Ribble Valley Borough Council
By email

Your ref: 3/2022/1039
Our ref: DC/22/3994 v2
Date: 02-FEB-23

Location: Land adjacent to 115 Kemple View Clitheroe BB7 2QJ

Proposal: Proposed construction of two new detached dwellings with associated access and garden areas

PROPOSED SITE PLAN

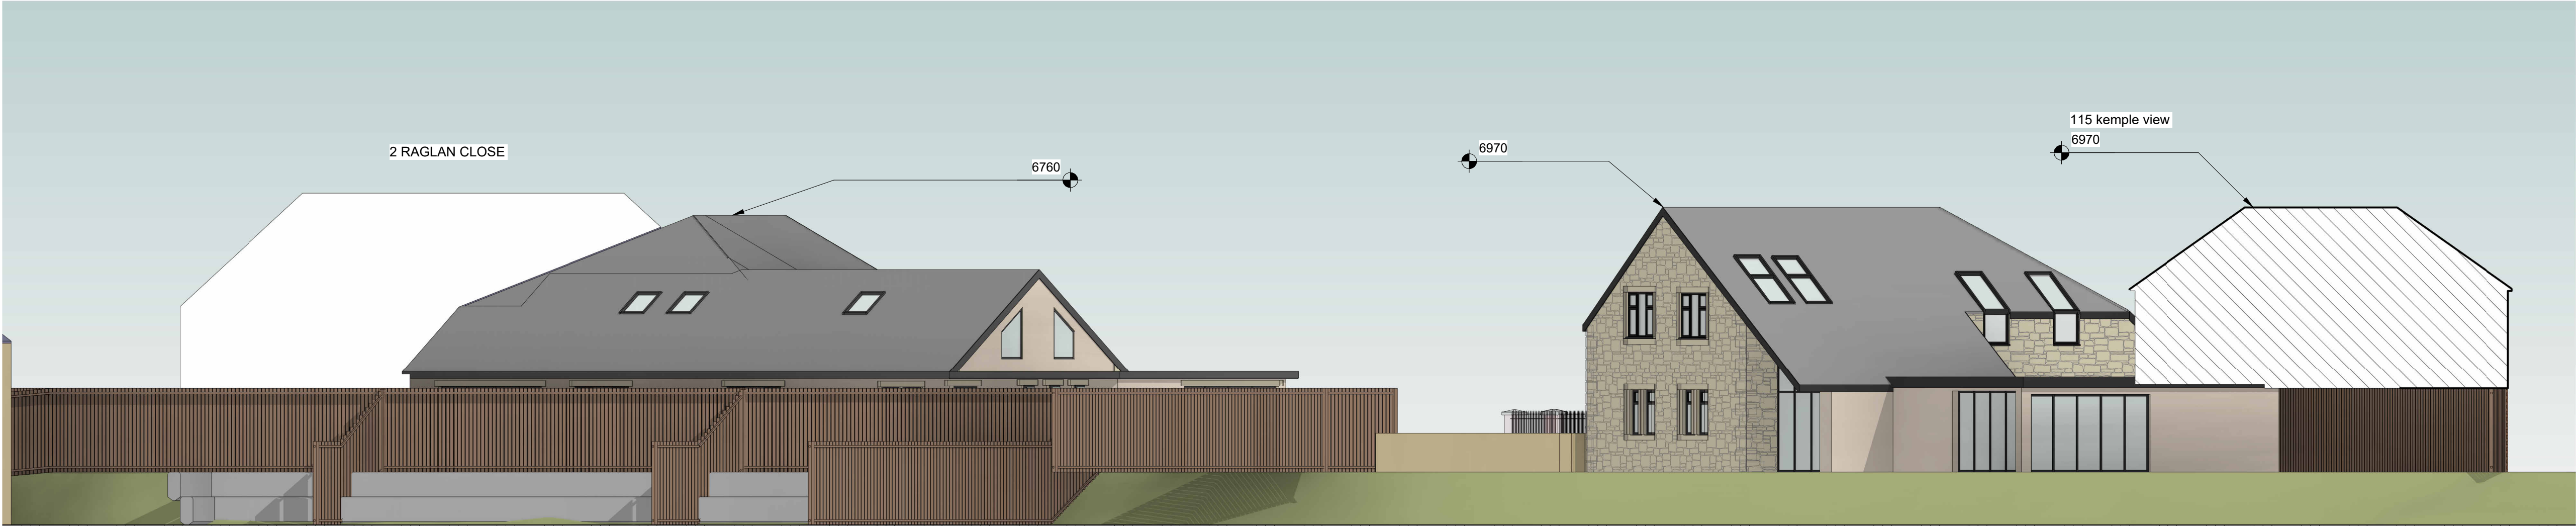
Following our review of the proposed site layout, we can confirm that the proposal is not acceptable to United Utilities as proposed features appear to be located in close proximity to our critical large diameter brick egg sewer. Until such time as the applicant has resolved all concerns regarding the proximity of the proposed development to our assets, our position is that we must **OBJECT** to the proposal. The applicant should contact our Developer Services team to discuss this further. See Contacts Section below.

- While we have received images of the CCTV survey, we need to understand how the accurate lines/routes and depths of the sewers have been determined. We request that evidence/further information is provided to demonstrate this.
- We request information on the proposed highway drain diversion method and design to ensure this will not have a detrimental effect on our sewers.
- We request that a 10m easement/standoff is provided from the 1100 x 650mm brick egg sewer in line with our easement local practice guidance, due to the criticality of the sewer. The guidance can be found as follows:

- We request footing details for the proposed buildings, demonstrating there will be no additional loading on our sewers.
